9 Portland St.

Renovations

Preble St. Resources

**From:** Marge Schmuckal  
**To:** Kandi Talbot  
**Date:** Tue, Apr 29, 2003 11:38 AM  
**Subject:** 9 Portland Street - Preble Resource Center

<p>PSRC 5 portland street portland, maine</p>	<p>architect: james sterling, aia 142 high street portland, maine</p>	<p>date: 22 april 03</p>	
<p>owner: preble street resource center portland, maine</p>	<p>lower level demolition</p>	<p>scale: 1/4" = 1' - 0"</p>	<p>north</p>
		<p>A- 0.2</p>

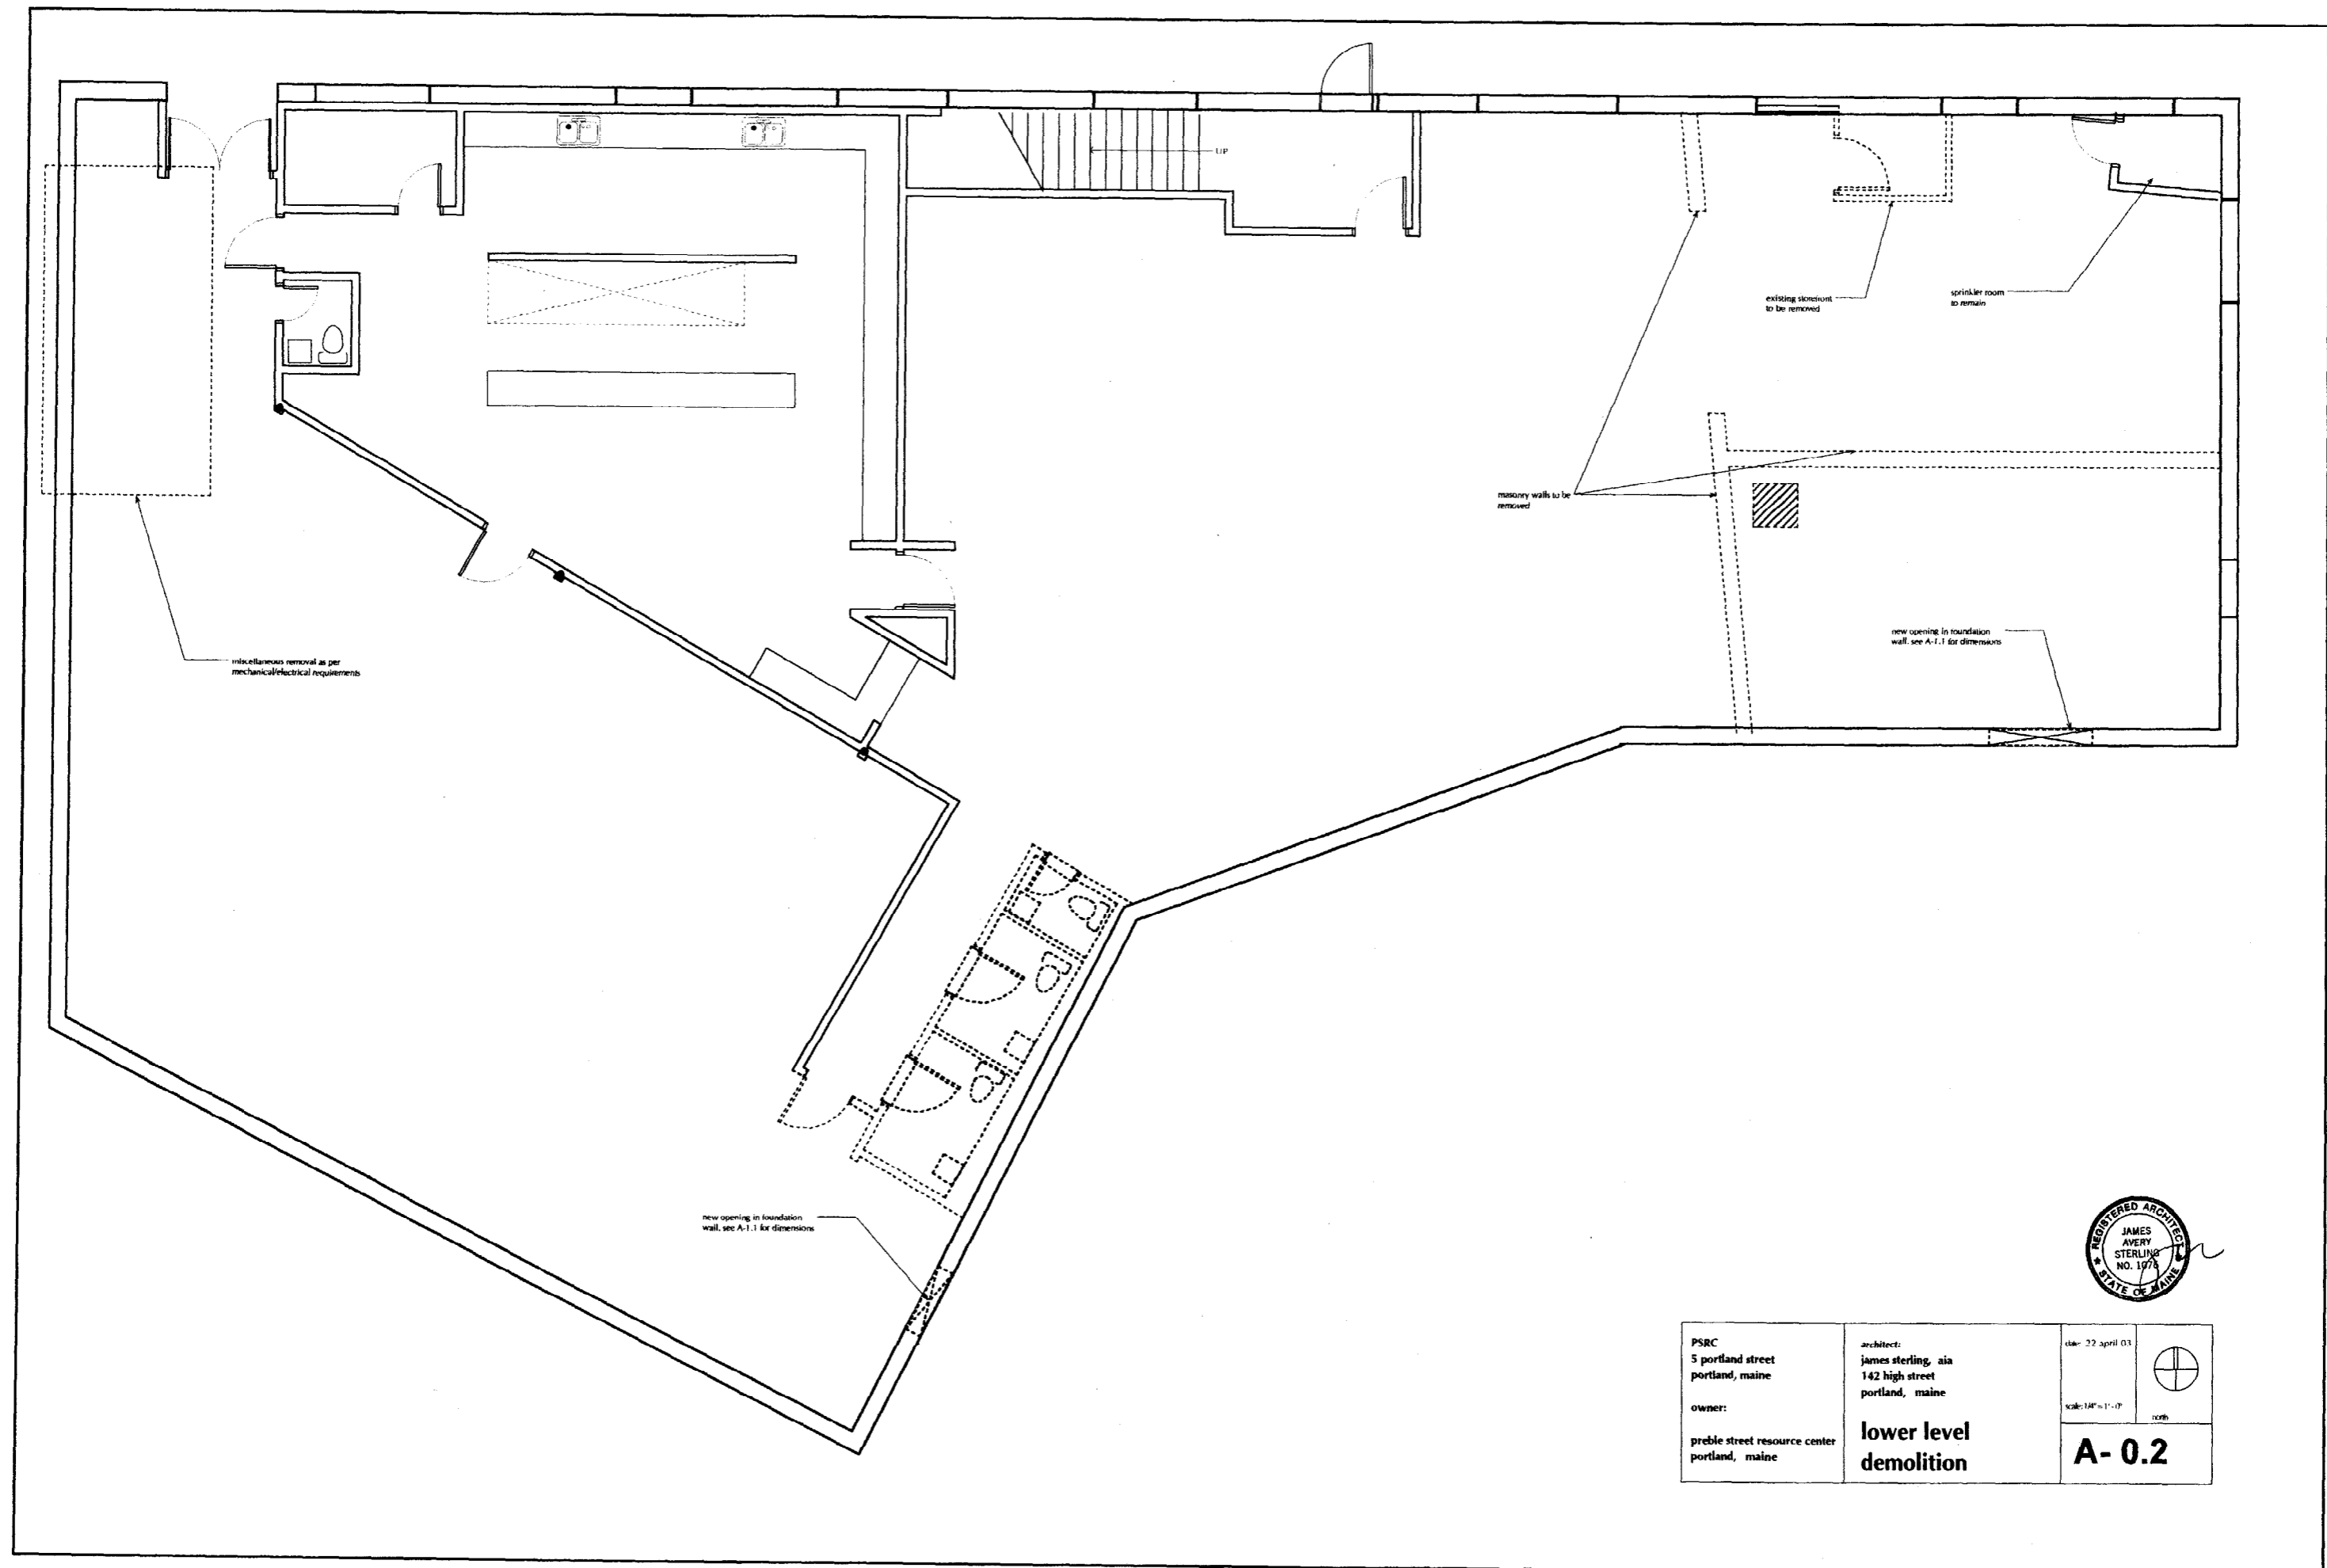
I also do not see actual lot lines shown on the site plan. On both Preble and Portland Streets, the plans are labeled that the addition is set back to property lines. But the building looks setback to some other given line. Don't you require actual property lines to be shown on submittals?

<p>PSRC 5 portland street portland, maine</p> <p>owner: preble street resource center portland, maine</p>	<p>architect: james sterling, aia 142 high street portland, maine</p> <p>upper level renovations</p>	<p>date: 22 april 03 revision:</p> <p>scale: 1/4" = 1'-0"</p> <p>sheet A- 1.1</p>
---	--	--

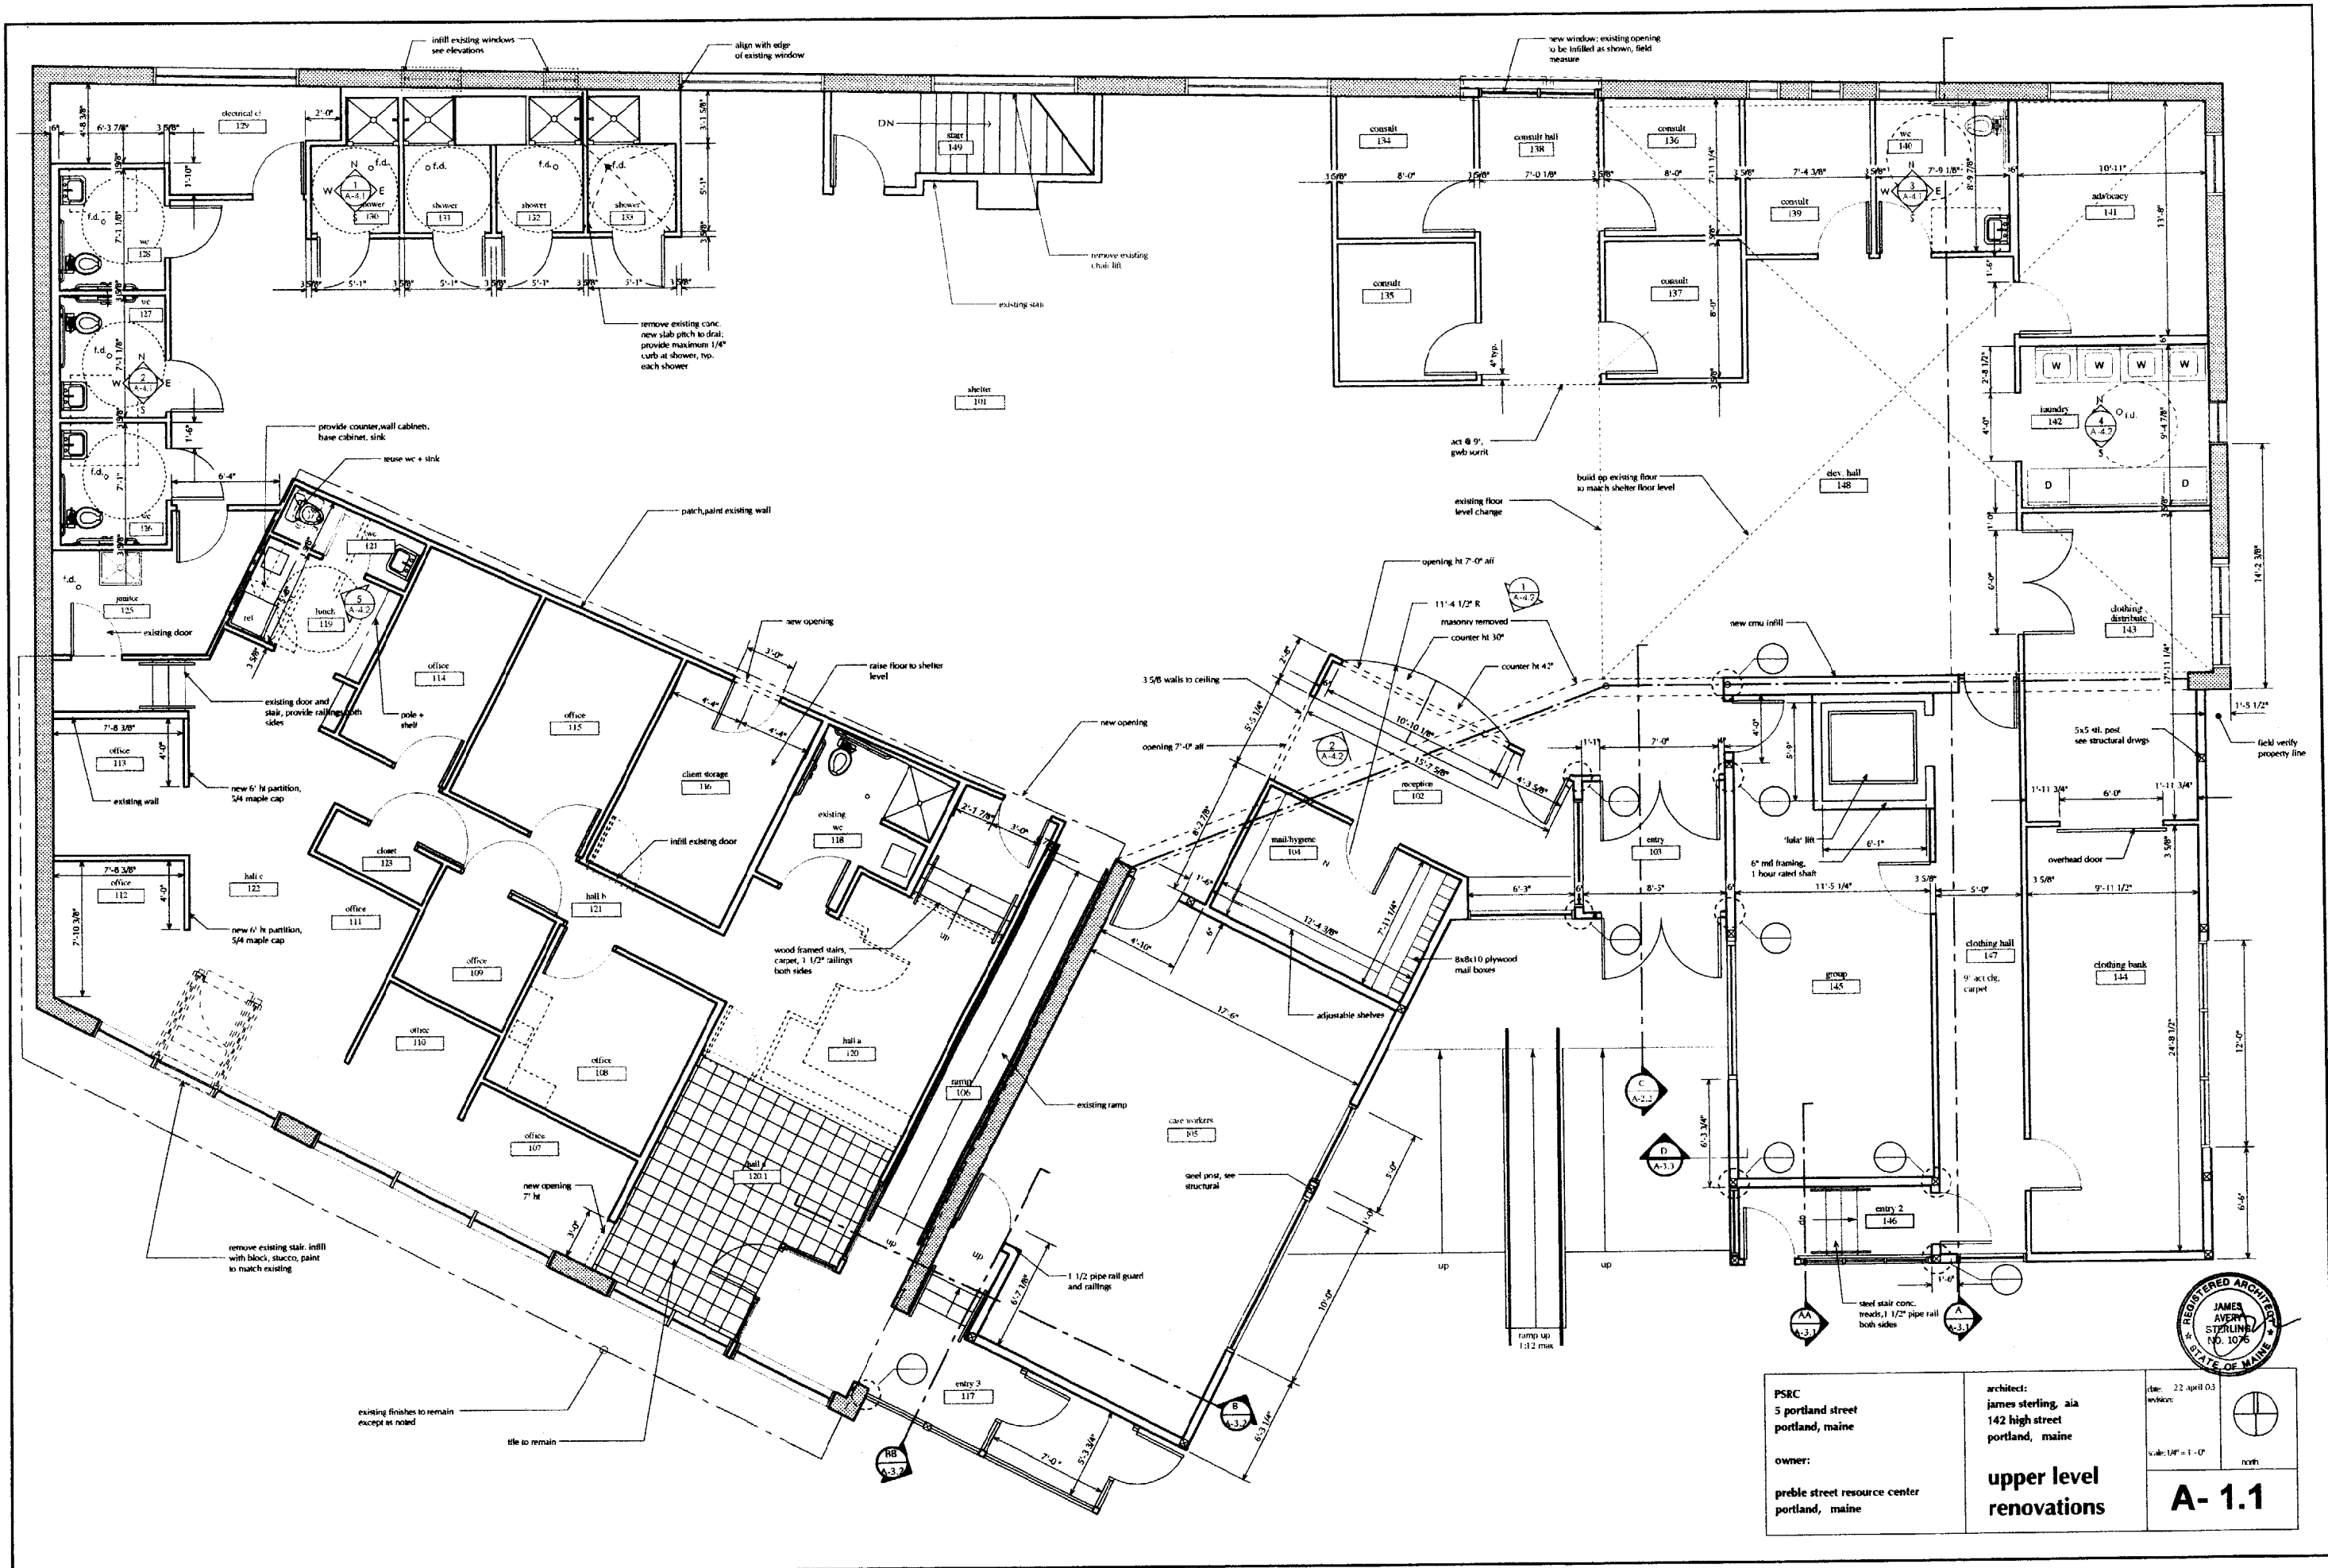
I am also uncertain as to parking requirements. I need some clarification as to labeled uses shown on the plans. On the upper level renovation area that is labeled "coordinaters", is that office space? Is the "clothing bank" area a public assembly area? On the lower level renovation area, what is the food pantry area? Is it a public assembly area, or is it a storage area?

PSRC 5 portland street portland, maine owner: preble street resource center portland, maine	architect: james sterling, aia 142 high street portland, maine elevations	date: 22 april 03 scale: 1/4" = 1'-0" A-2.1
--	---	--

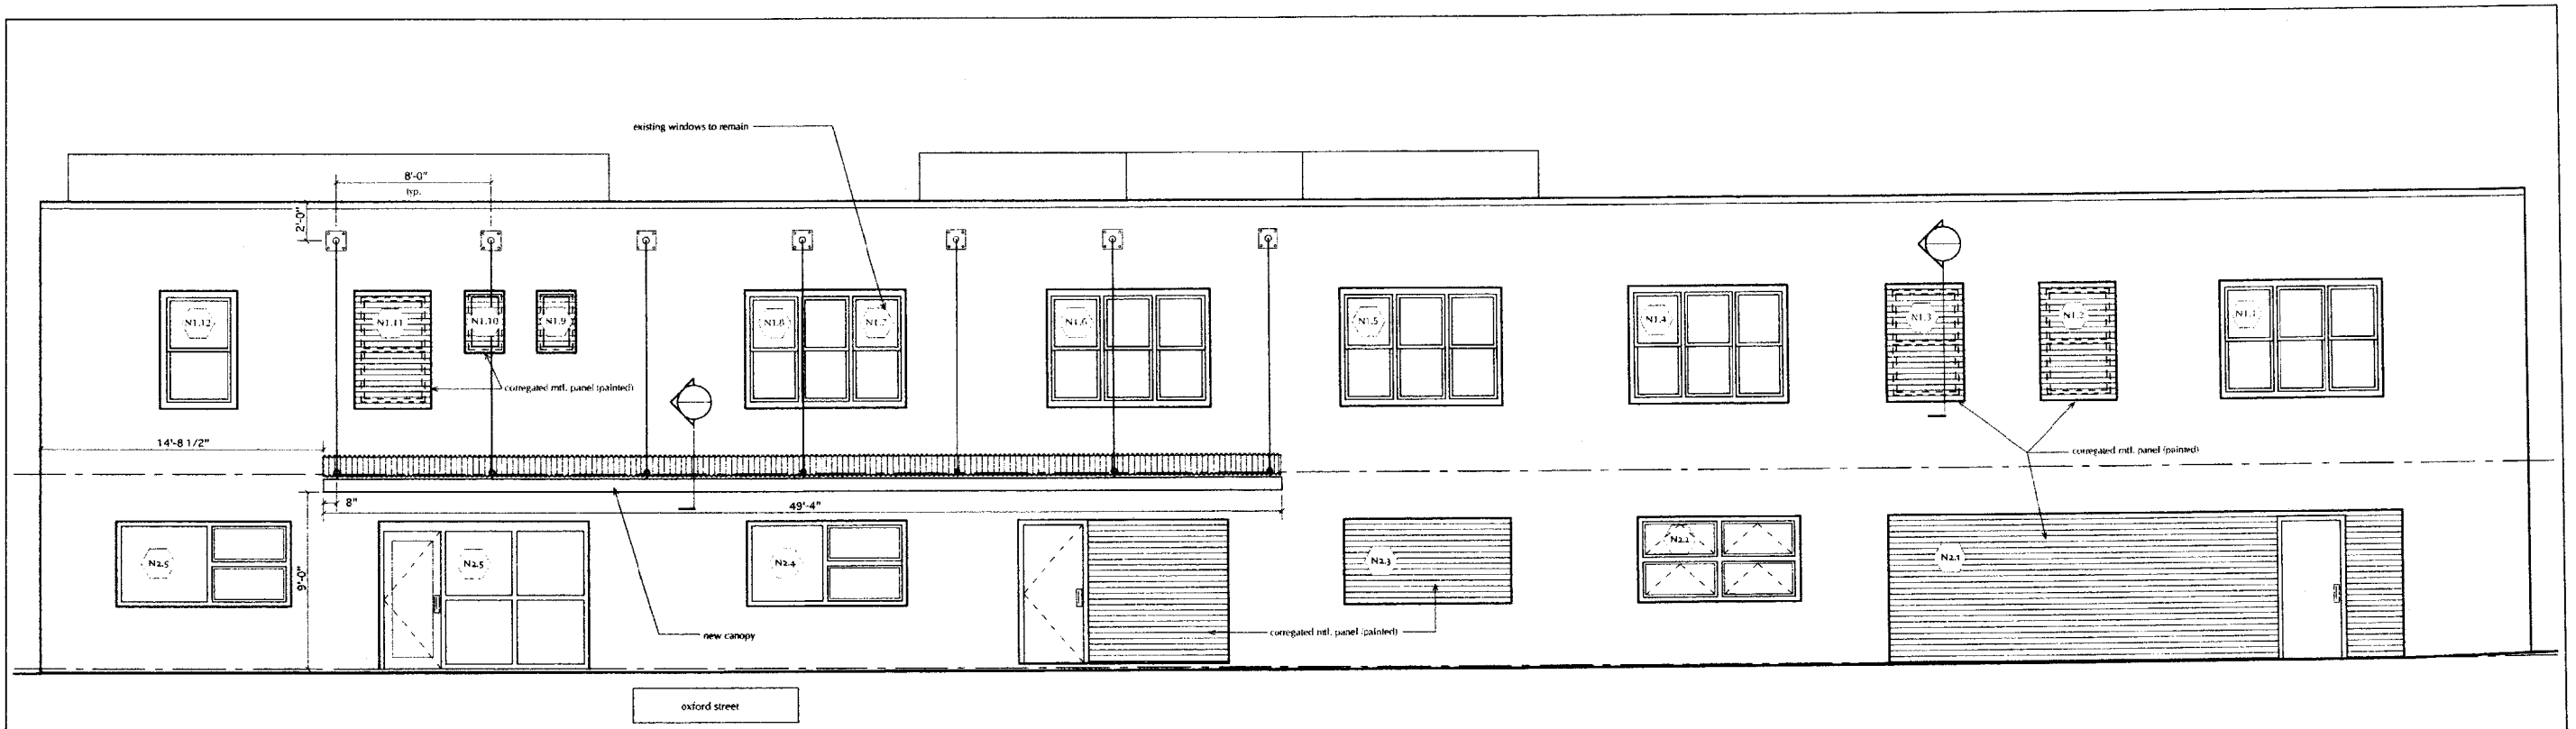
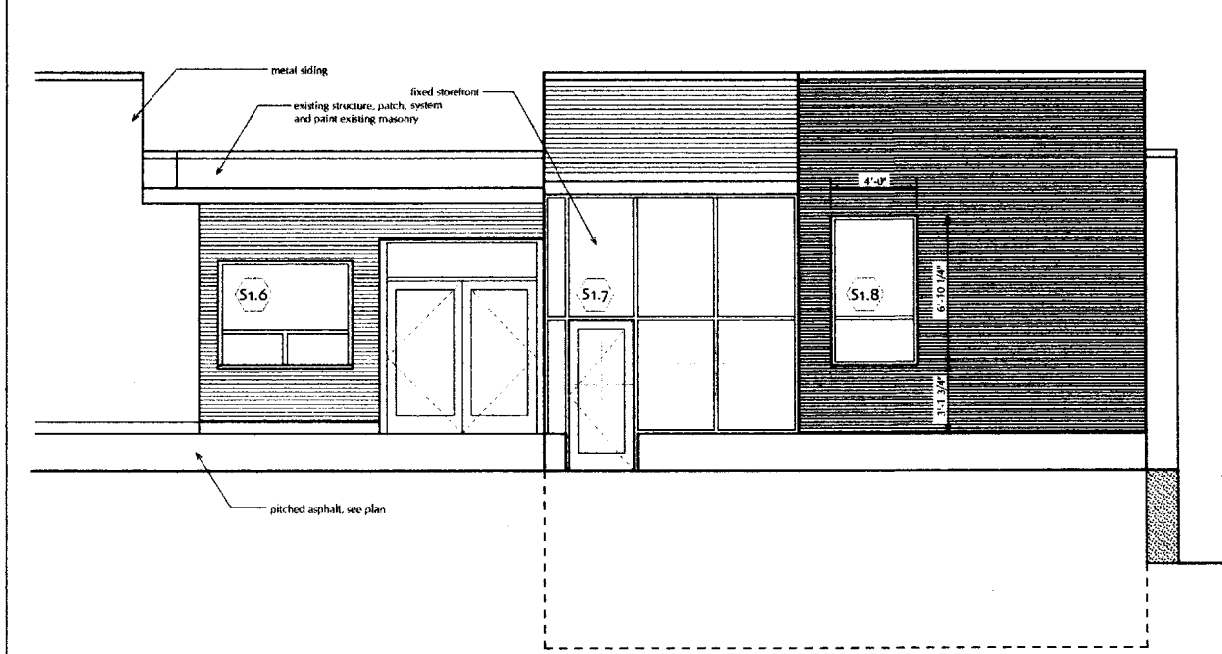
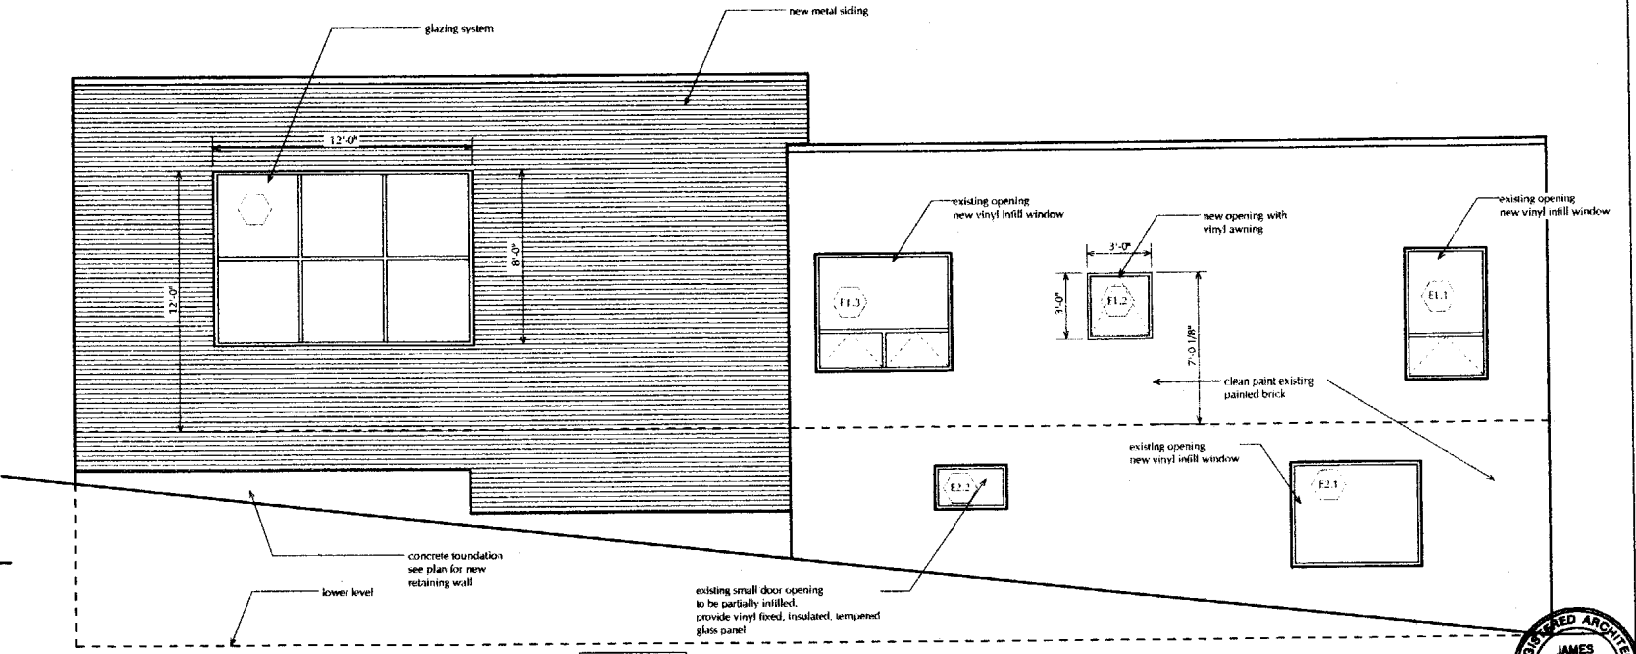
I have reviewed this site plan submittal. There is one zoning violation concerning height. Section 14-220 states: " No new construction of any building shall be less than thirty-five (35) in height within fifty (50) feet of any street frontage except for parking adendant booths or bank remote teller facilites". I am measuring only 22 feet in height.
